**From:** Julie Grieves on behalf of Planning.Responses  
**Sent:** 23 November 2015 09:41  
**To:** Tracey Headley-Smith; Corinne Clowes  
**Subject:** FW: Hascombe 33 Tamarisk Way - EP/120/15/HH  
**Attachments:** 1043.38b Proposed Ground & First Floor Plans.pdf; 1043.39a Proposed Second & Roof Plans.pdf; 1043.40a Proposed Sections.pdf; 1043.41b Proposed Elevations.pdf; 1043.42b Proposed Ground & First Floor Overlays.pdf; 1043.43a Proposed Second Floor & Roof Plan Overlays.pdf; 1043.44b Proposed Elevations with Overlays.pdf; 1043.45 Proposed Site Plan.pdf

**From:** Chris Bark [REDACTED]  
**Sent:** 13 November 2015 11:44  
**To:** Anita Gardner  
**Cc:** 'Jason Richardson'; Rebecca Hoad  
**Subject:** Hascombe 33 Tamarisk Way - EP/120/15/HH

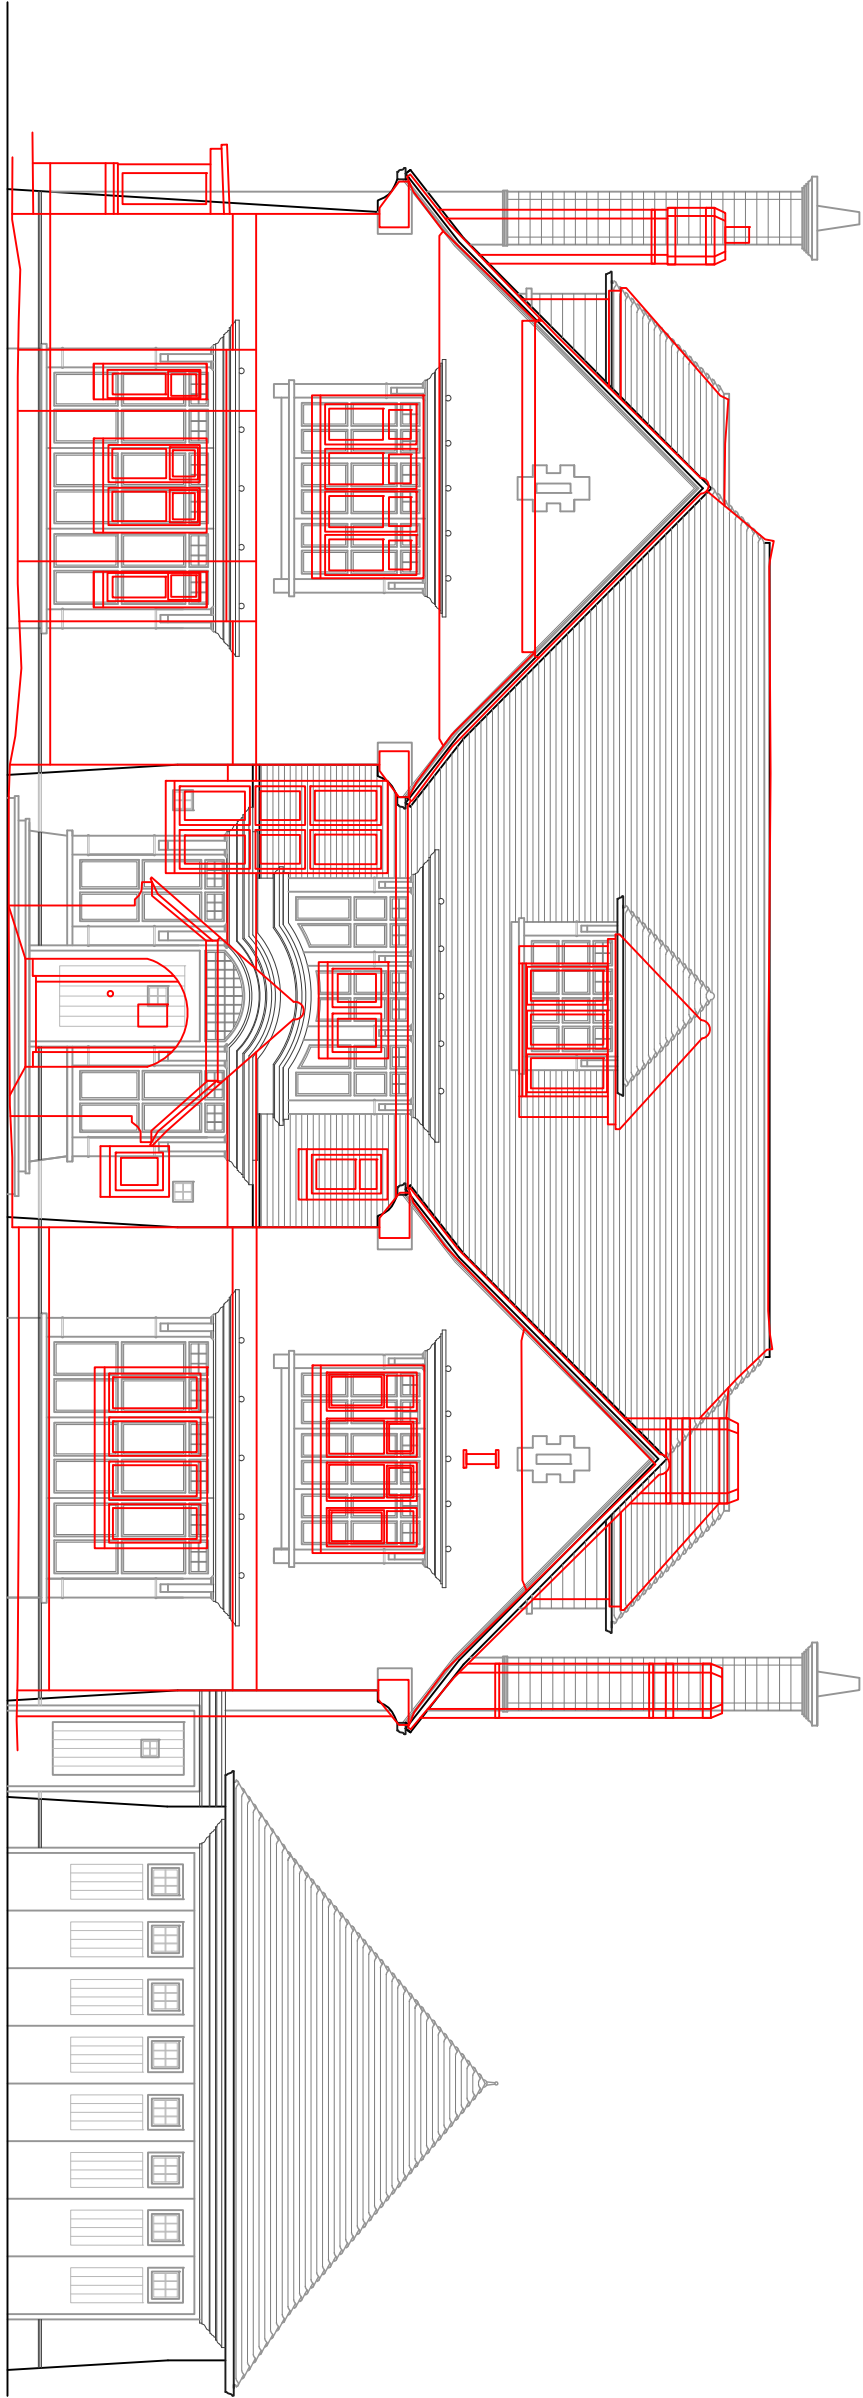
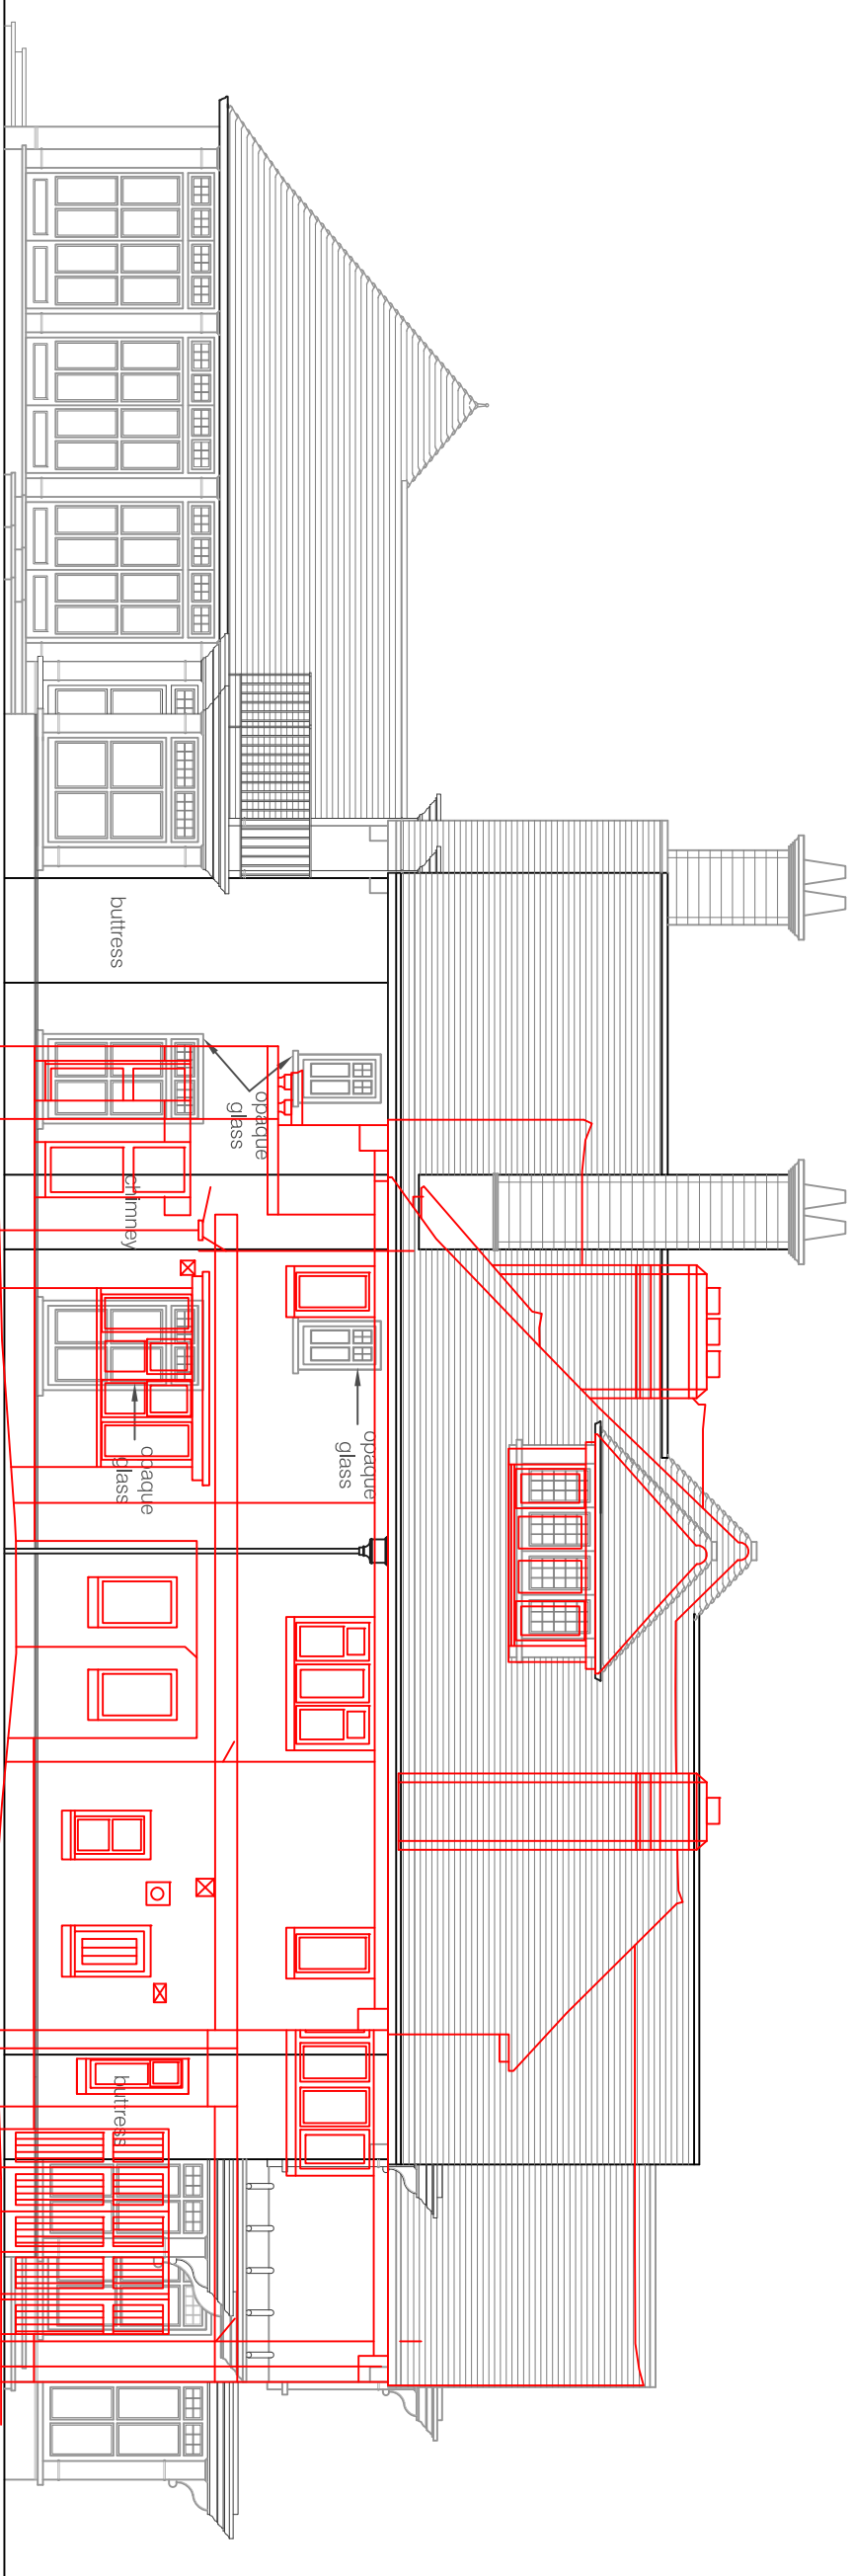
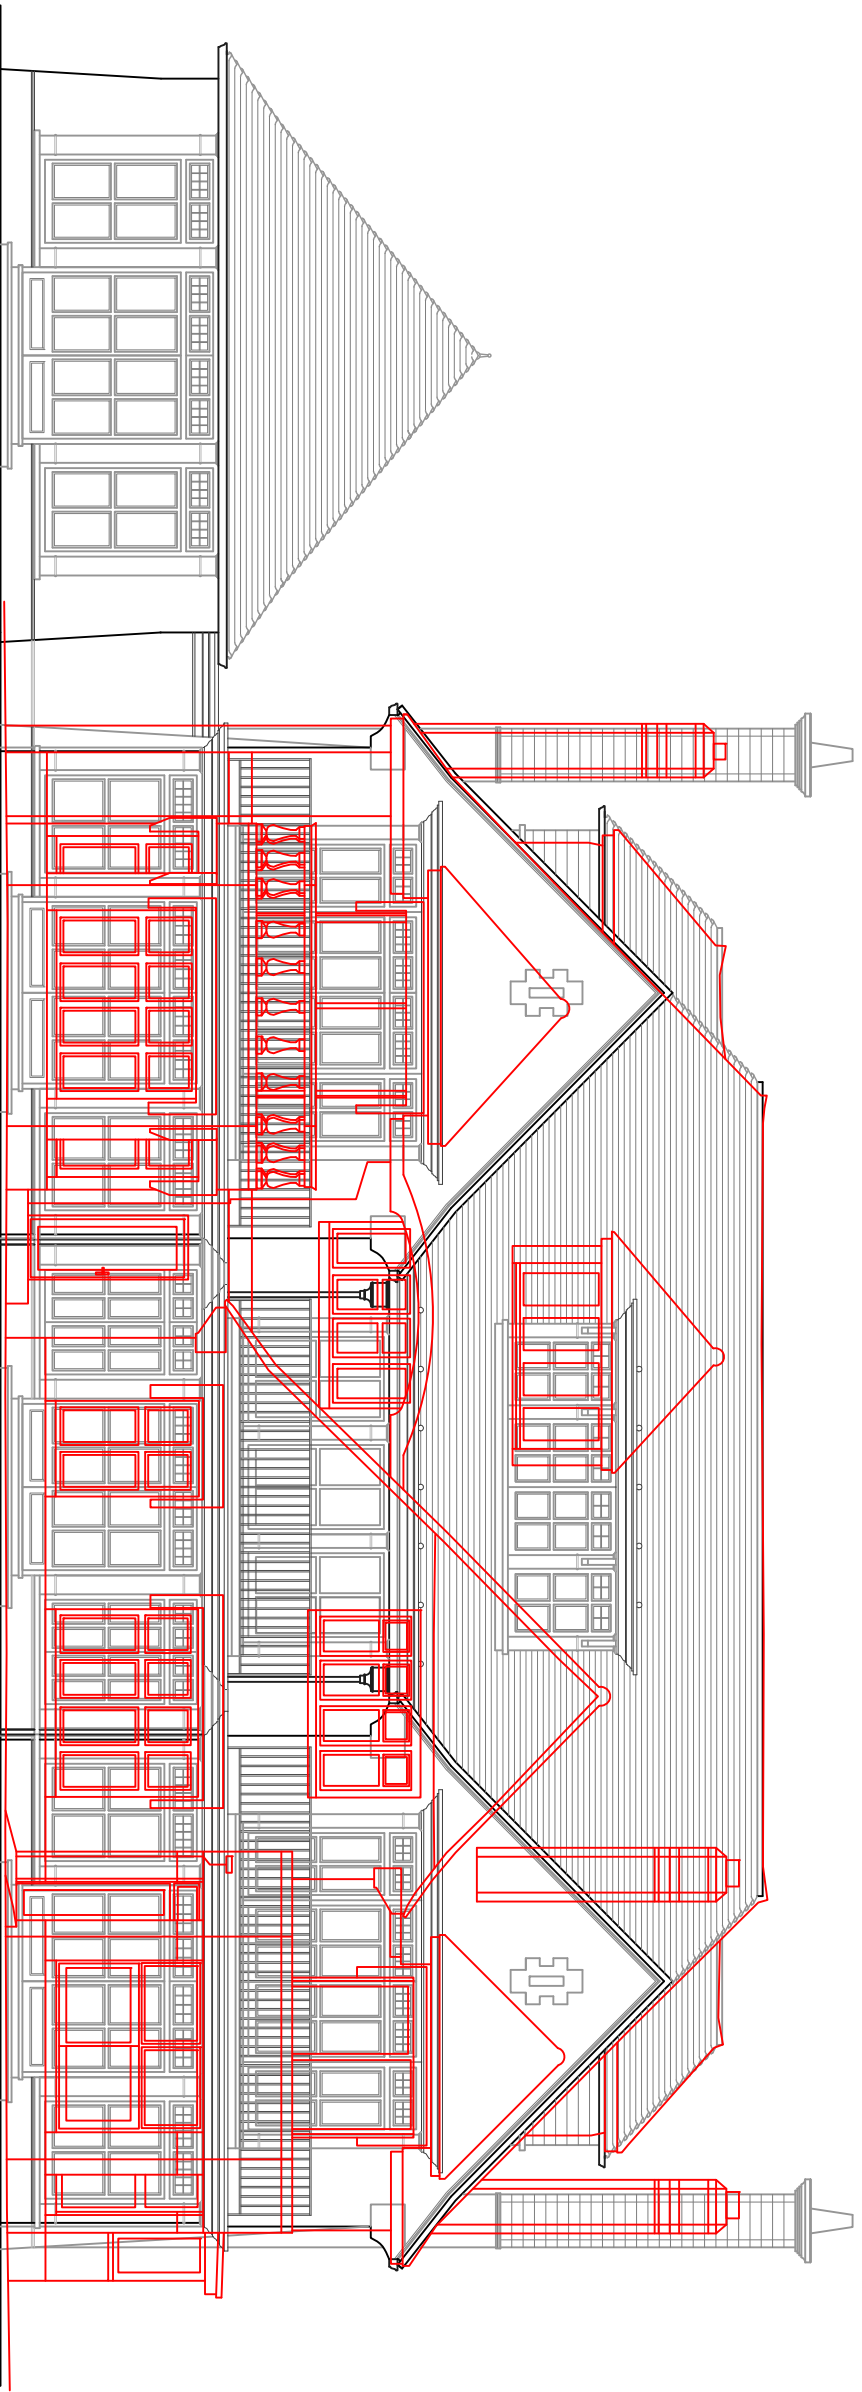
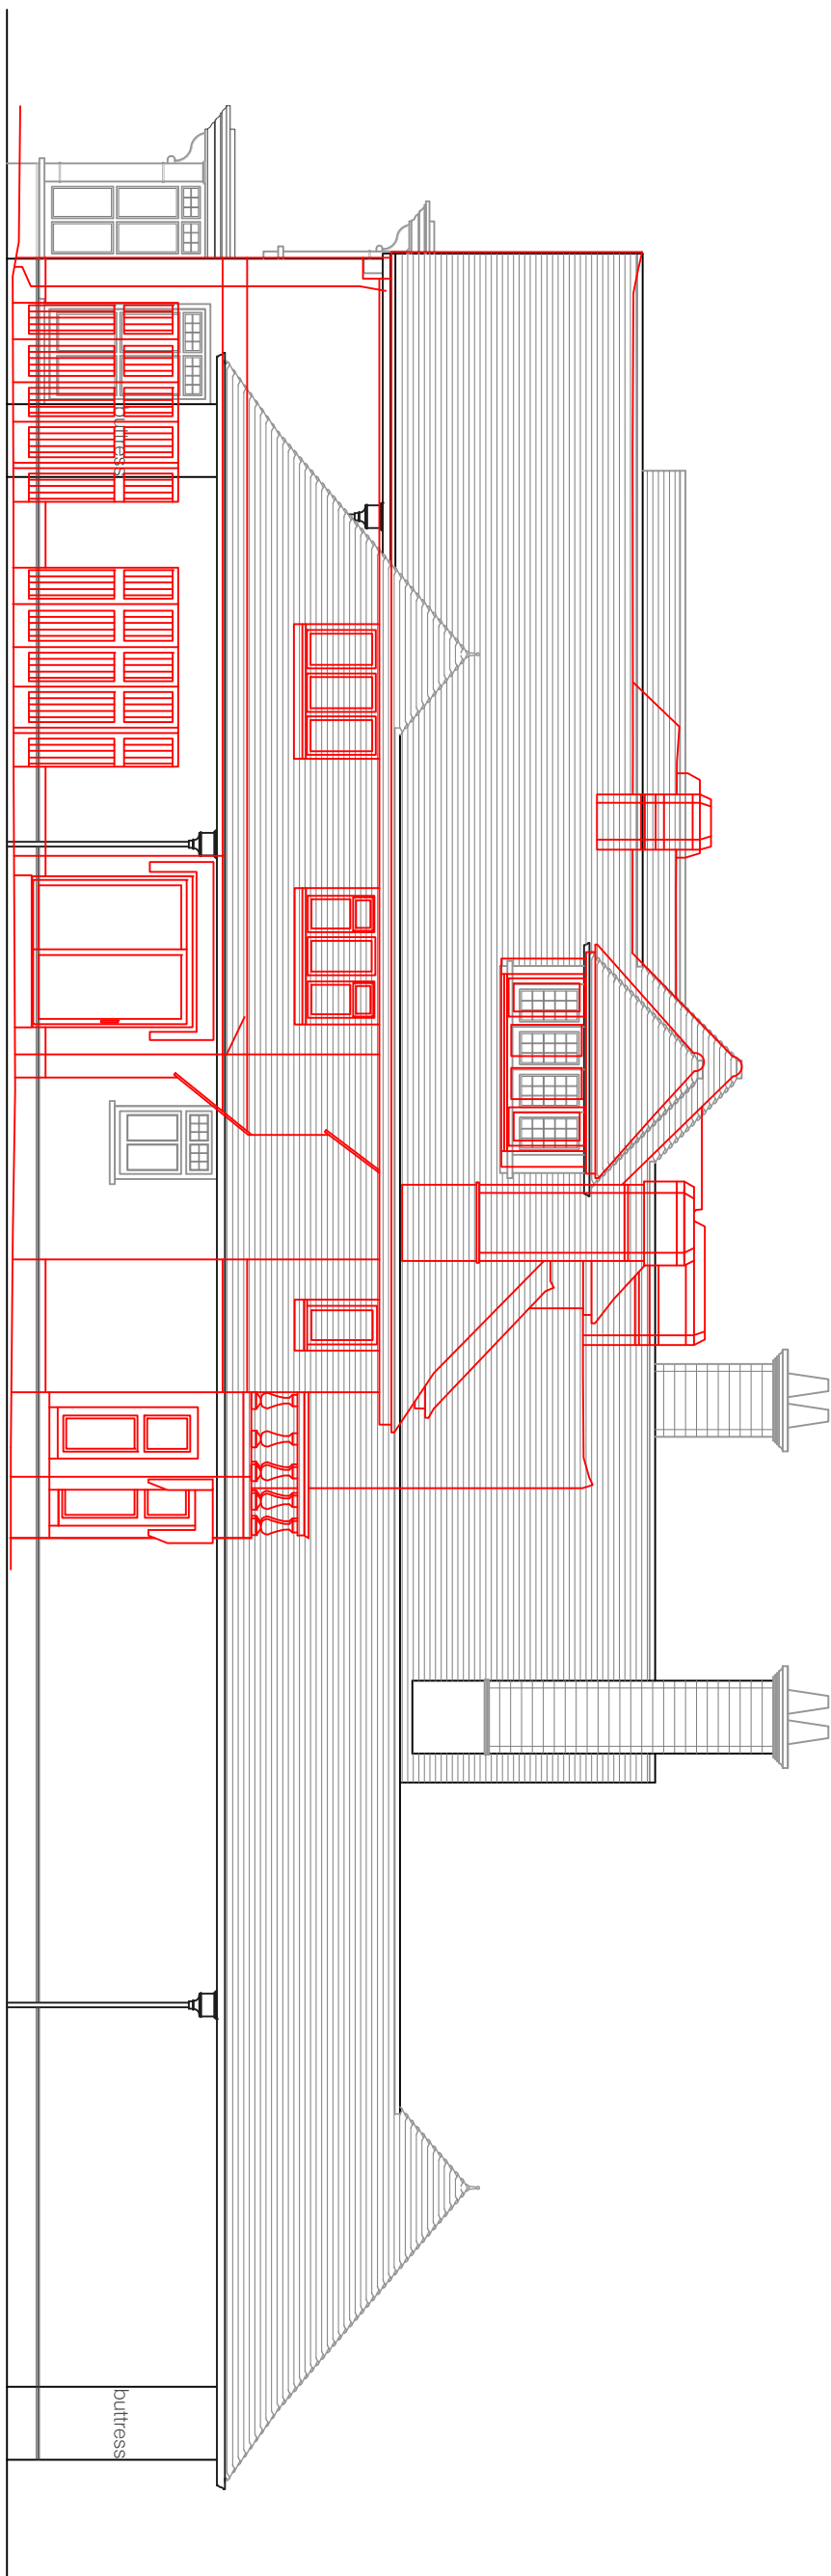
The amendments to the scheme focus on the reduction in rearward depth of the eastern extensions to the property, which concerned the neighbour in respect of outlook, prospect and sunlight.

The scheme has been amended to pull back the depth of the rear projection at this point almost in line with the existing rear elevation as can be shown on the overlaid elevations (1043.44b). In addressing this issue the scheme extends the property further to the north-east (front), which would not have such potential impacts on the neighbouring property. The extensions proposed to not breach the existing frontage building line present currently and retain the previously proposed character of the dwelling.
